## Development Application and Planning Proposal Review NSW Planning Portal Concurrence and Referral

Authority	Authority's Reference	Agency Concurrence and Referral	Authority Contact	Authority Notification	Submission Due	Submission Made
NSW Department of Planning, & Environment	SSD-41372302		Tuong Vi Doan	15/10/2022	14/11/2022	19/10/2022

Address	Land Title
Elara Boulevard, Melonba	Lot 30 DP 1237735

Environmental Impact Statement (EIS) for the Marsden Park High School and Melonba Public School. New primary school and new high school to cater for 3000 students and 219 staff.

Drawing Title
SITE PLAN

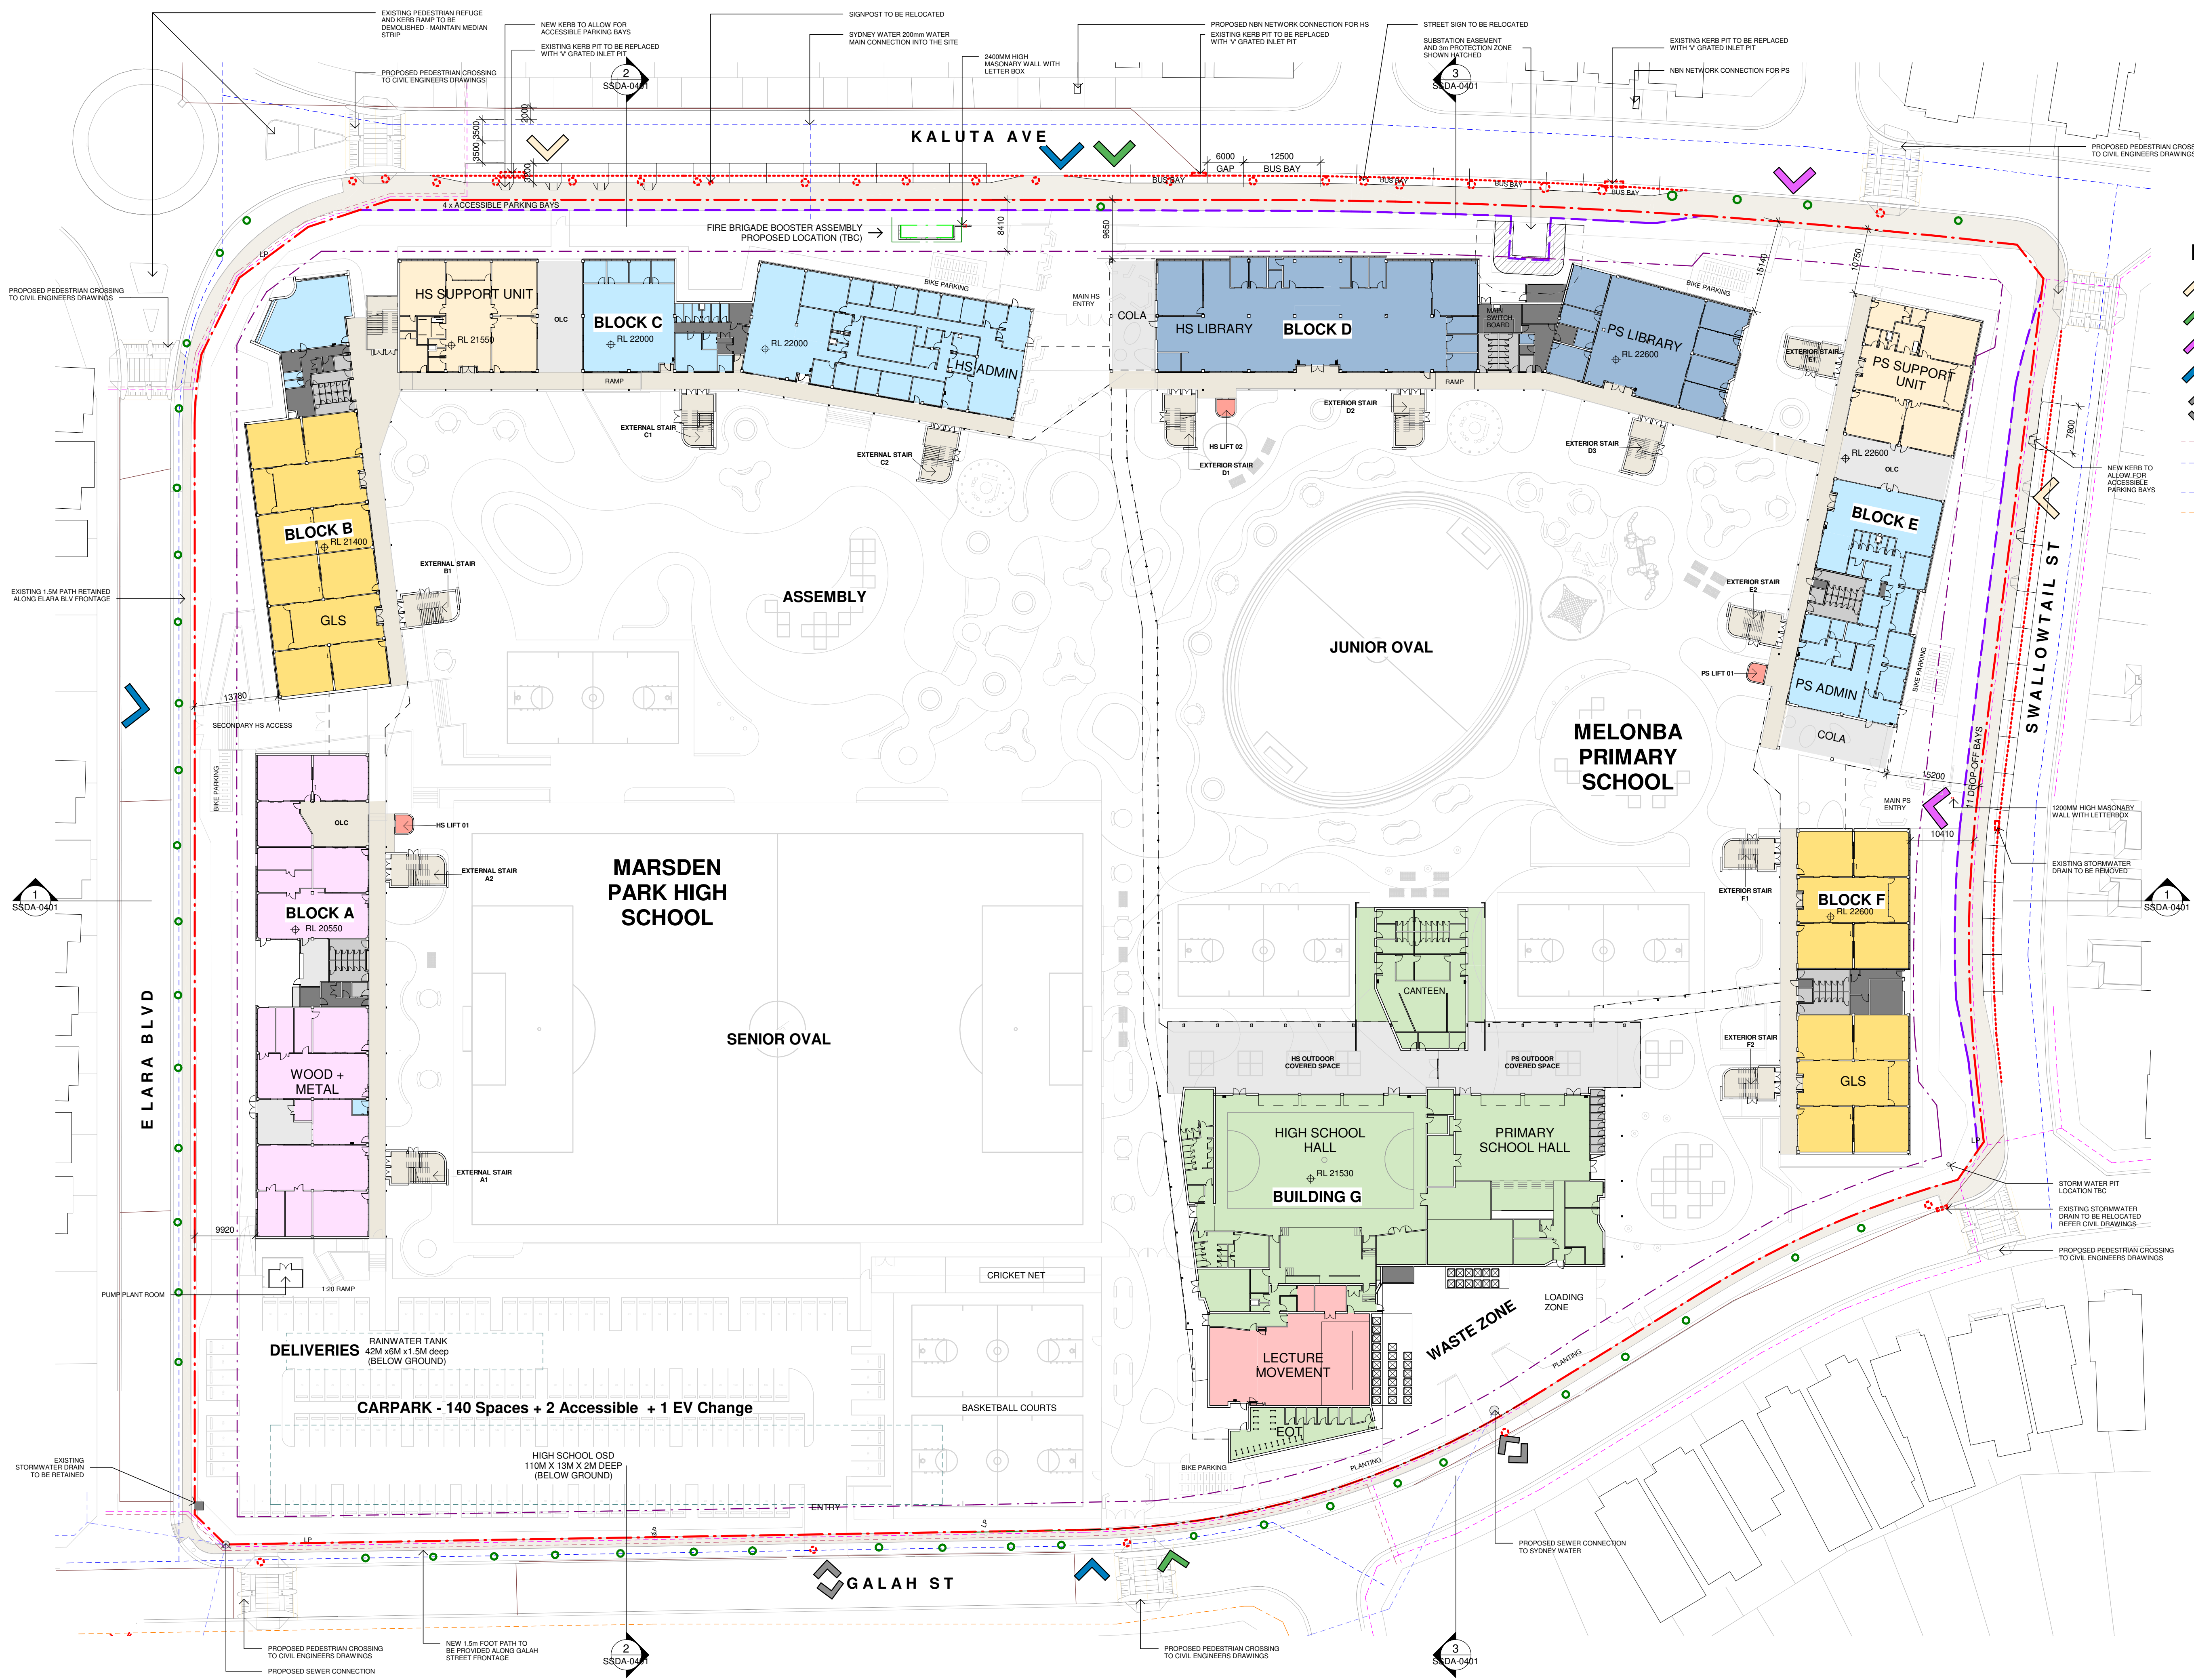
- The following extract of the Site Plan shows provision for 'Substation Easement and 3 m (Fire) Protected Zone' to the Kaluta Avenue road frontage.

- Driveways should be designed to increase the separation to the any electricity infrastructure on the road verge as much as reasonably possible. The Site Plan does not appear to show all the streetlight columns to the Swallowtail Street road frontage.
